Town Council

Application: 3/2025/0991

Considerations by Longridge Town Council

DRAWING TITLE  
**Location and Block Plan**

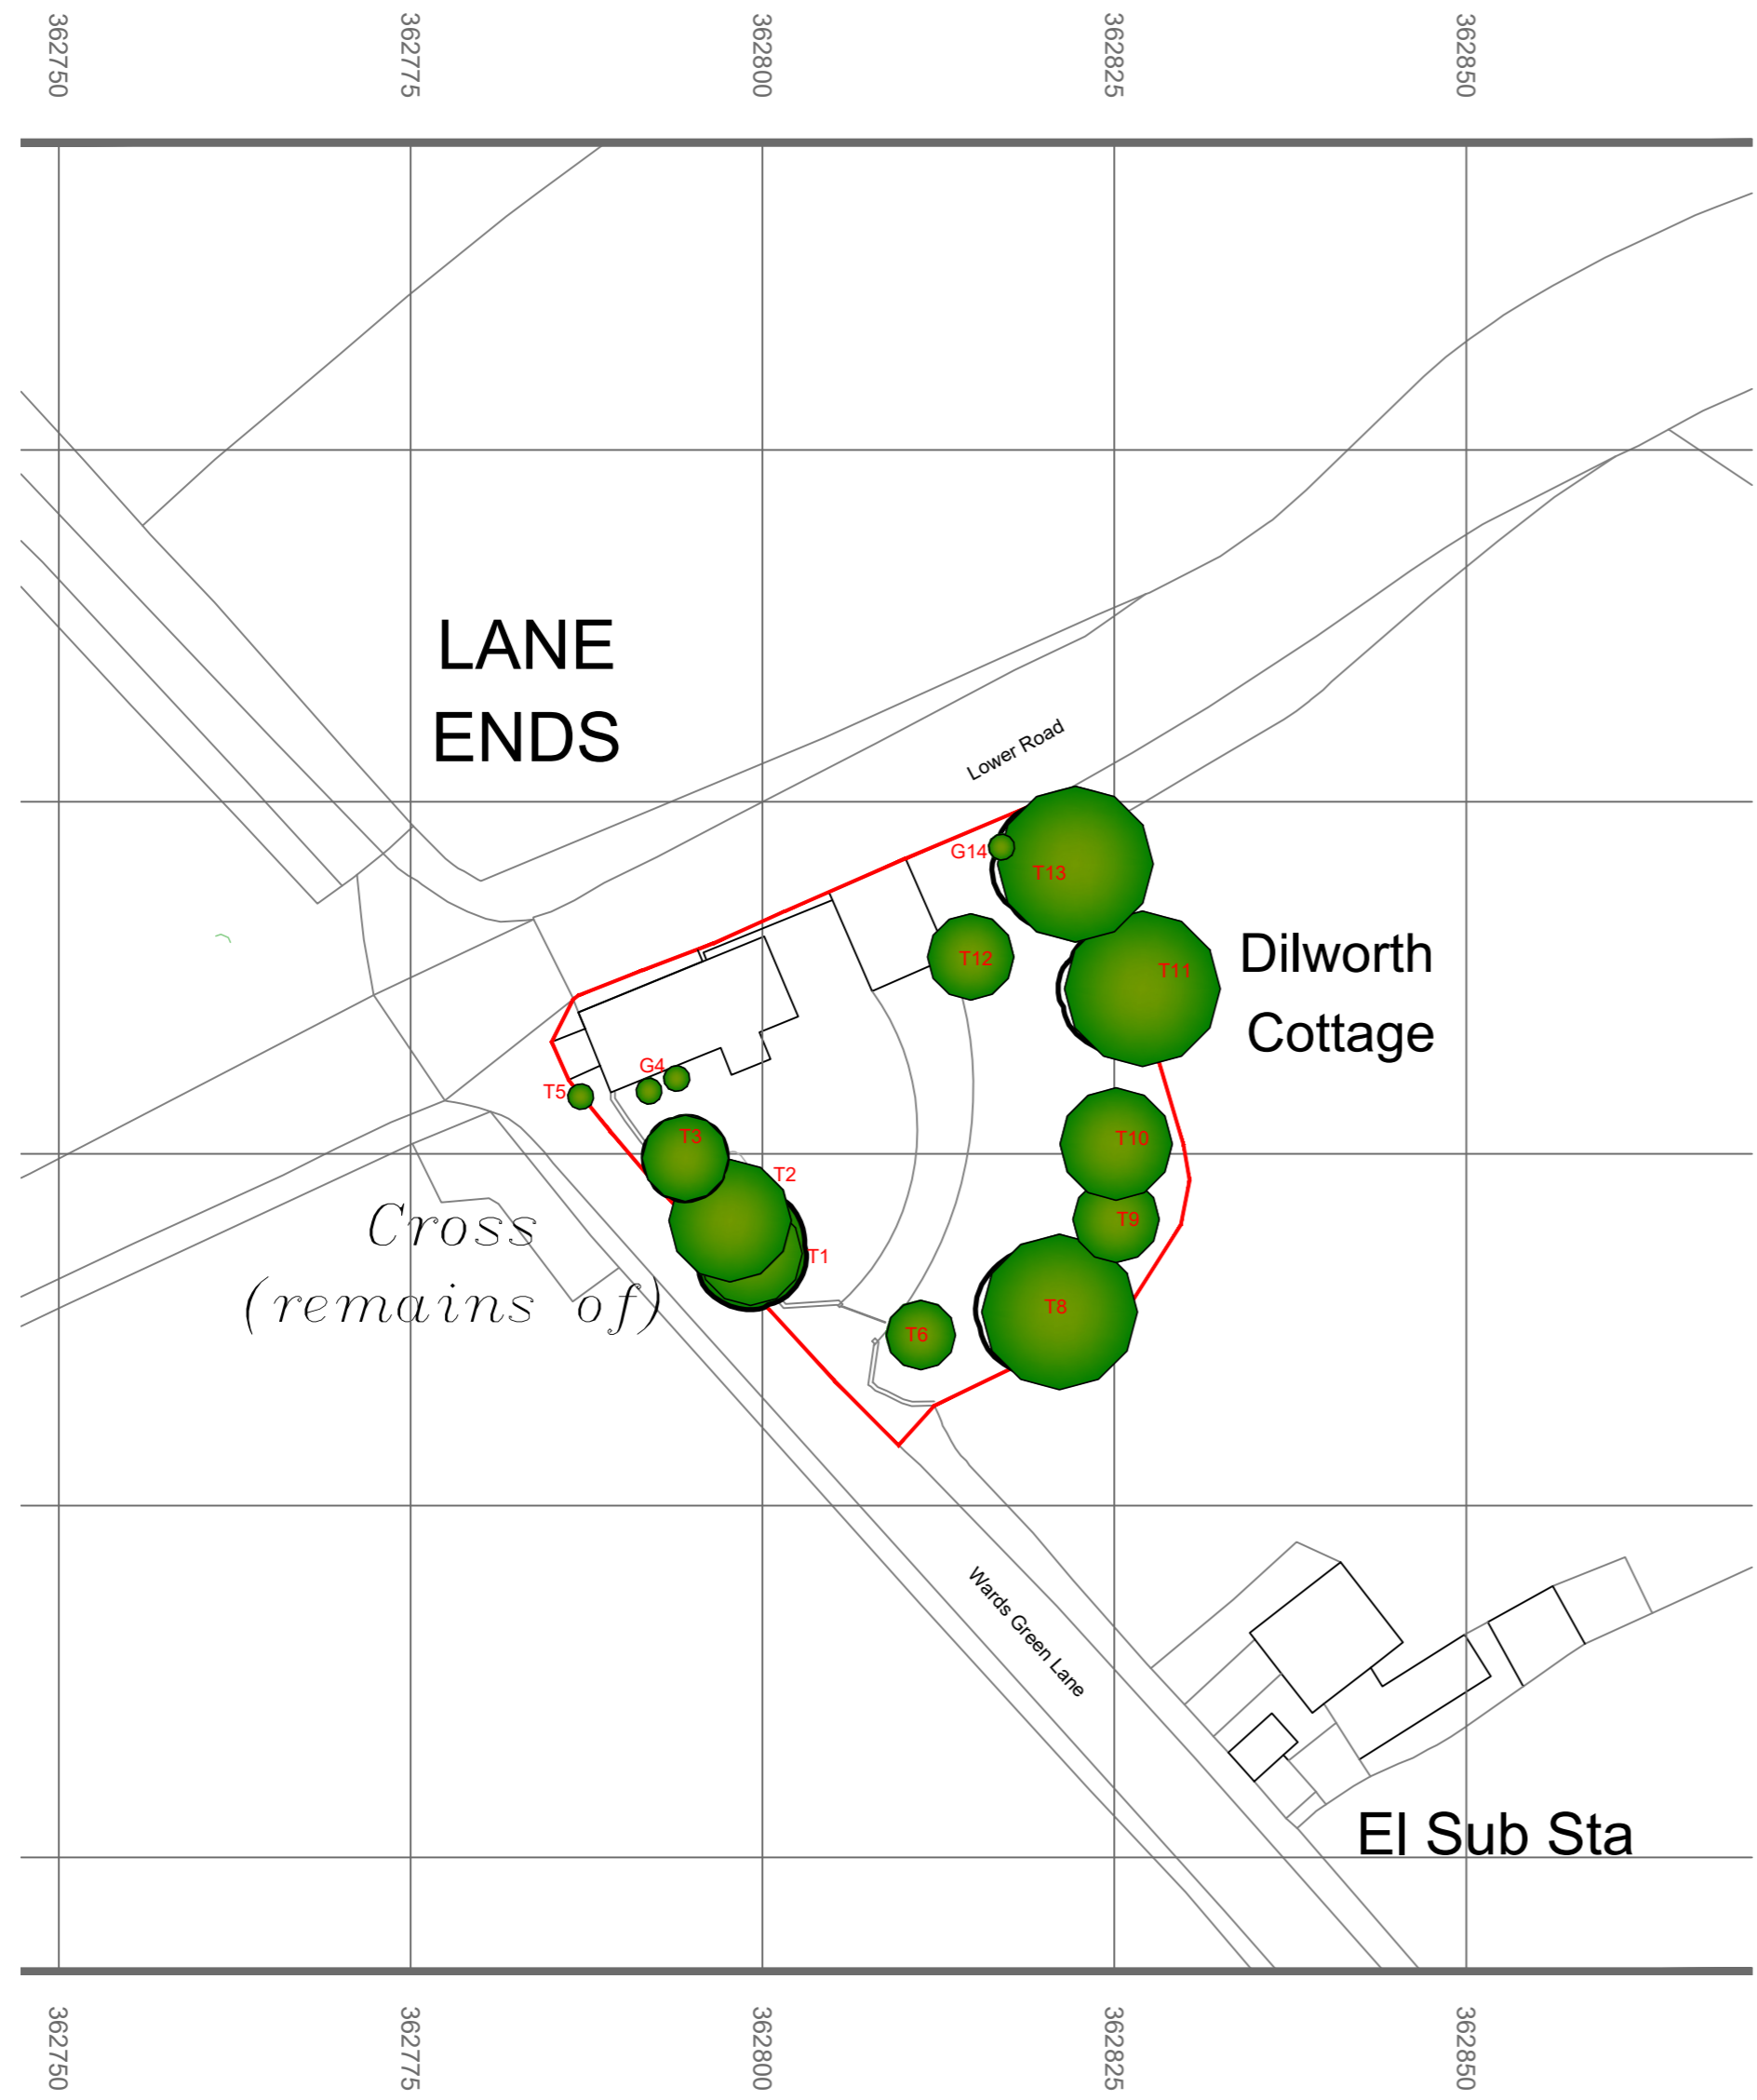
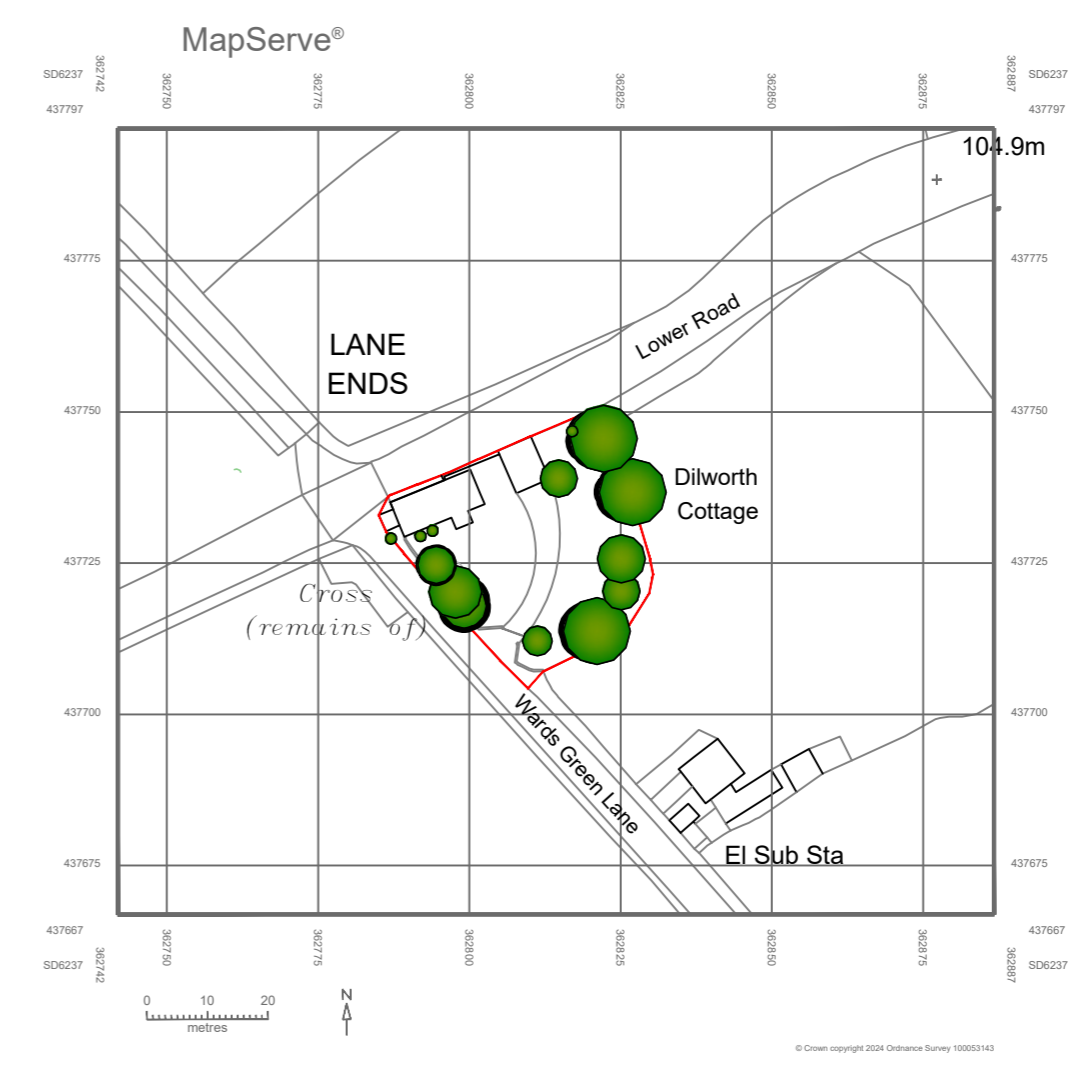
As this is a replacement dwelling on an existing site and as the previous site line when exiting Ward Green Lane on to Lower Road was not good. Would it be possible to move the new house to improve visibility for everyone.
